**RE: Chullora Materials Recovery Facility (SSD-10401)**

I refer to the notice of exhibition for the State Significant Development (SSD-10401) at 21 Muir Road, Chullora for the construction and operation of a materials recovery facility (MRF) with a maximum throughput up to 172,000 tonnes per annum of waste. I understood the MRF would process co-mingled and source separated dry waste from municipal, commercial and industrial sources, including paper, cardboard, glass, plastic and aluminium.

Figure 15 The location of the sensitive receptors, recreational areas and education facilities in the vicinity of the Proposal site

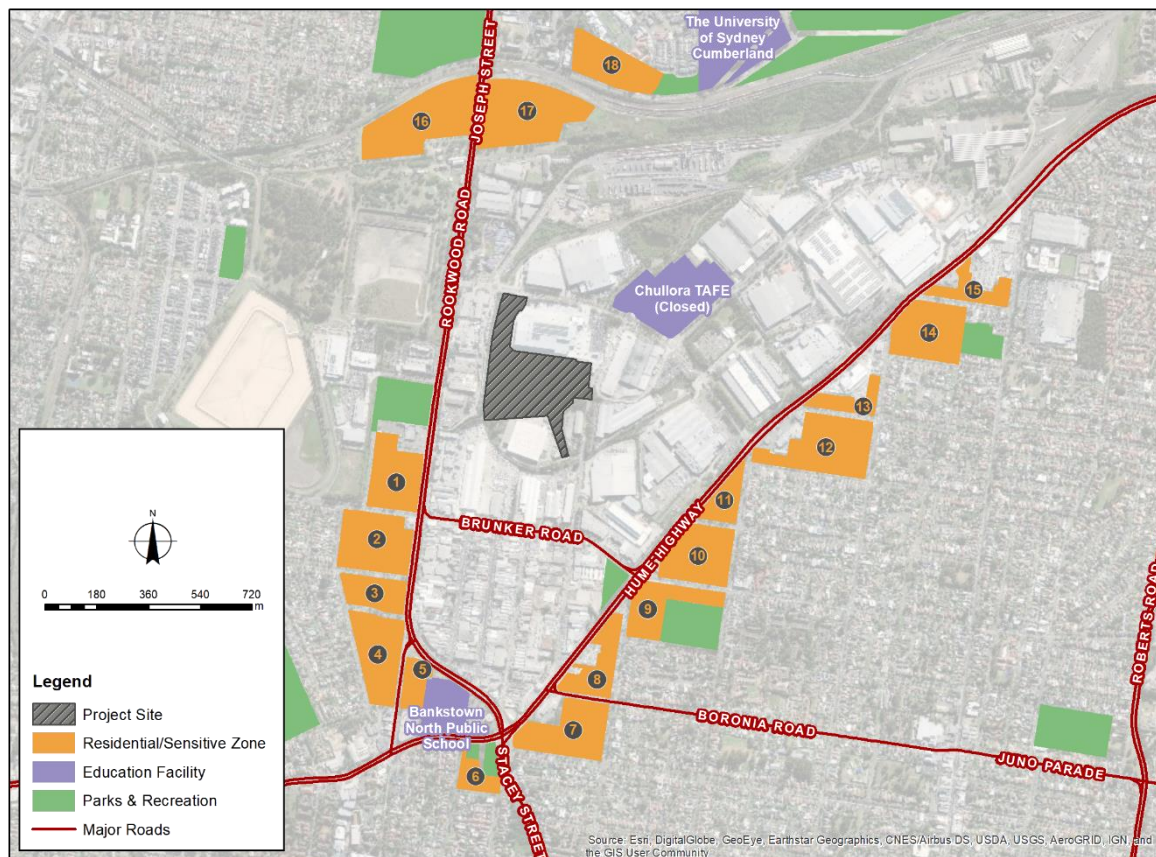
We note the above list is non-exhaustive regarding land uses. The air quality assessment by Katestone provides a thorough assessment of the impacts upon residential, educational and recreational receptors, but omits nearby, specifically adjoining land uses, including our client's site. Not only does the assessment not consider our client's site, outlined in red on Figure 1 below, but does not include an assessment of all adjoining land uses, which include many sensitive receptors, including commercial premises, such as food and drinks premises. We believe this to be a significant omission in the reporting and overall assessment that needs to be properly considered.

Further to the above, while the air quality assessment acknowledges the location of known sensitive receptors, it fails to provide for an assessment of likely future receptors. The air quality assessment must have regard to the future development potential of adjoining sites and wider area. The proposed MRF will likely have adverse impacts on the future development of surrounding land, which the air quality assessment fails to consider.
